PROJECT TITLE Parking Lot for NAPA Facility ^{Albuquerque} TYPE OF SUBMITTAL Drainage plan
ZONE ATLAS PAGE NO. J-14 CITY ADDRESS 1 2nd Street NW
LEGAL DESCRIPTION Lots 1 thru 8, Block 13, Paris Addition
ENGINEERING FIRM DMJM Adam Hamlyn Anderson CONTACT Jake Bordenave
ADDRESS 4055-A Montgomery Blvd. NE PHONE 881-1808
OWNER Genuine Parts Company CONTACT _____
ADDRESS 1510 2nd Street NW PHONE _____
ARCHITECT The Ken Hovey Design Group CONTACT Ken Hovey
ADDRESS 3700 Simms Avenue SE PHONE 255-4756
SURVEYOR _____ CONTACT _____
ADDRESS _____ PHONE _____
CONTRACTOR Farmer Corporation CONTACT Steve Henderson
ADDRESS 3535 Girard Blvd. NE PHONE 884-1366
DATE SUBMITTED MARCH 6 1984
BY Regi Rutar

March 23, 1984

RE: GRADING & DRAINAGE PLAN FOR PARKING LOT FOR NAPA
ALBUQUERQUE FACILITY (J14-D40) RECEIVED MARCH 6, 1984

GRADING & DRAINAGE PLAN

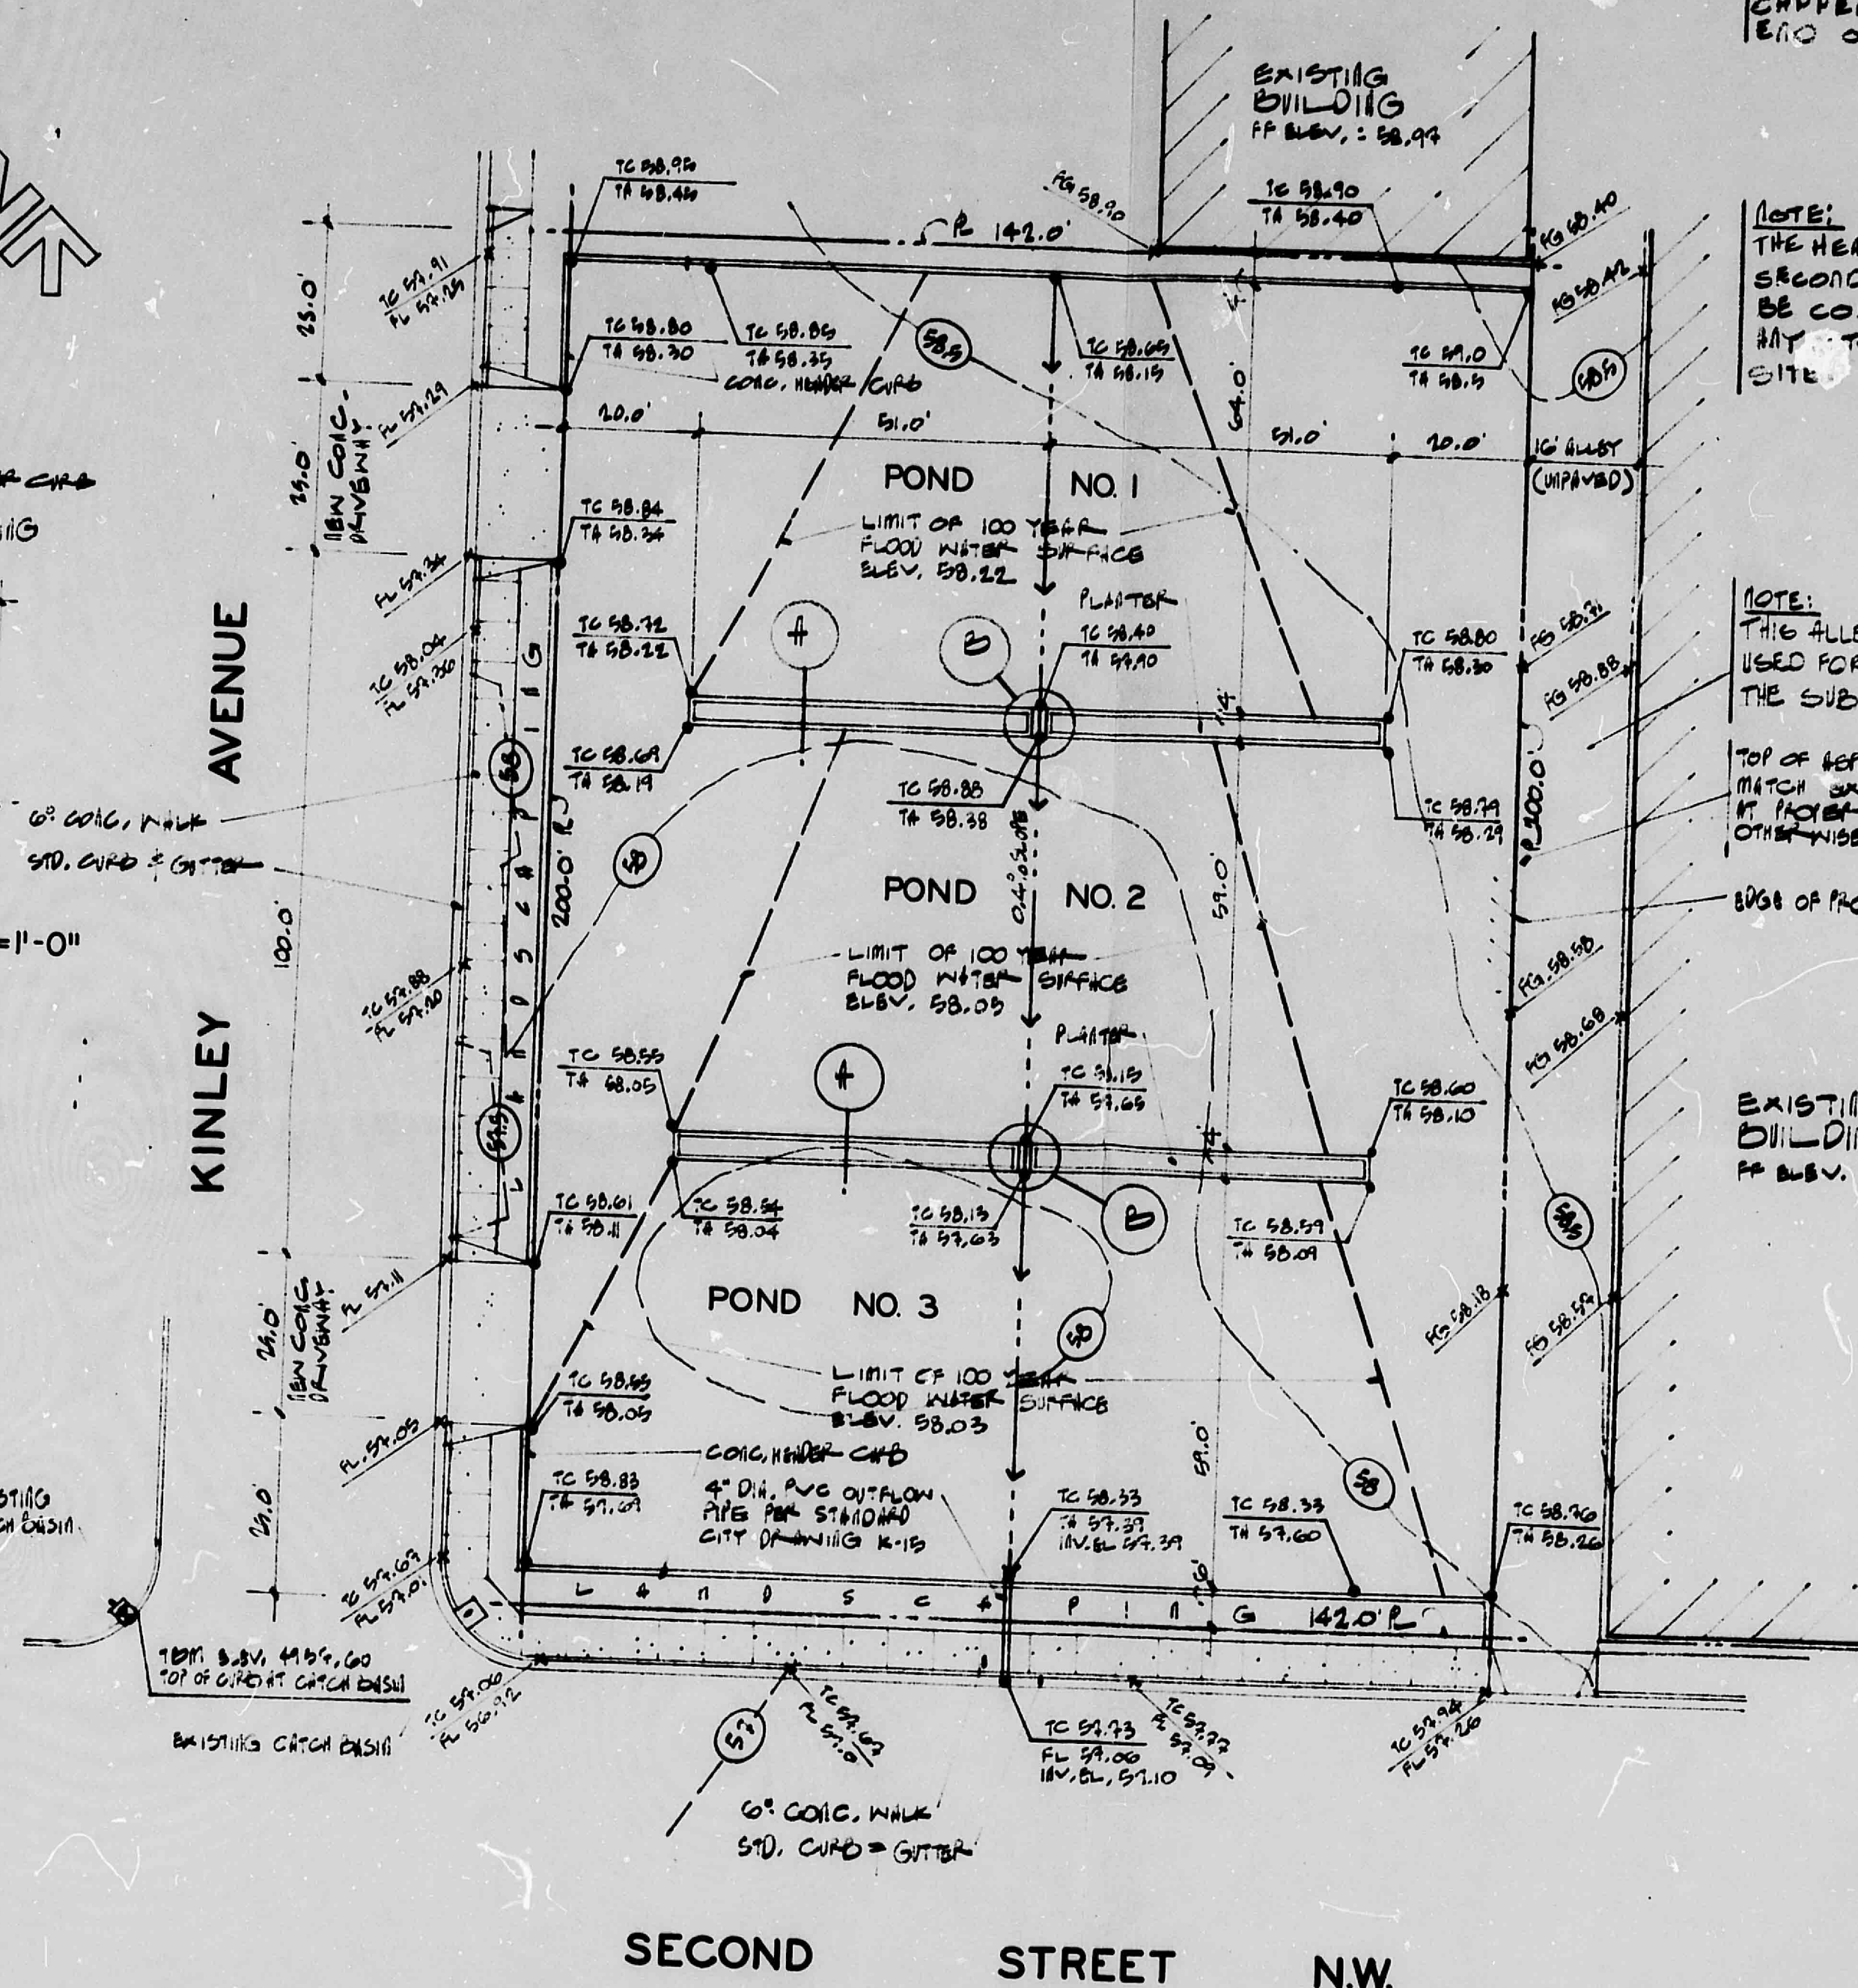
- ✓ 1. The off-site flows have not been addressed.
- ✓ 2. What is the discharge rate from the site and how will it be achieved? The plan indicates a 4" sidewalk culvert but, there is no further mentioning of it. What is the head on this pipe? I cannot verify if it will work. Where are the emergency spillways? What do they look like?
3. The plan indicates that the site is adjacent to an alley. Approved alley grades are required.
4. The plan should have the legal description on it or the current plat should be provided.
5. An Erosion Control Plan should be provided for the period of construction.

1. There is no offsite flow entering this site
2. Peak discharge rate from the site is 0.289 cfs with a maximum head of 0.48 feet and emergency spillways is the Drivepad located at the NW corner of the site.
3. A note has been added to the plans and the site shall not be accessible from the adjacent alley. The existing alley is approximately 1/2 foot above the finish floor of the adjacent building and I would rather not be responsible for setting grades and subjecting myself to the potential liability that could be incurred.
4. Legal description has been added to the plans.
5. A note regarding sequence of construction has been added to the plan, which will affect Erosion Control.
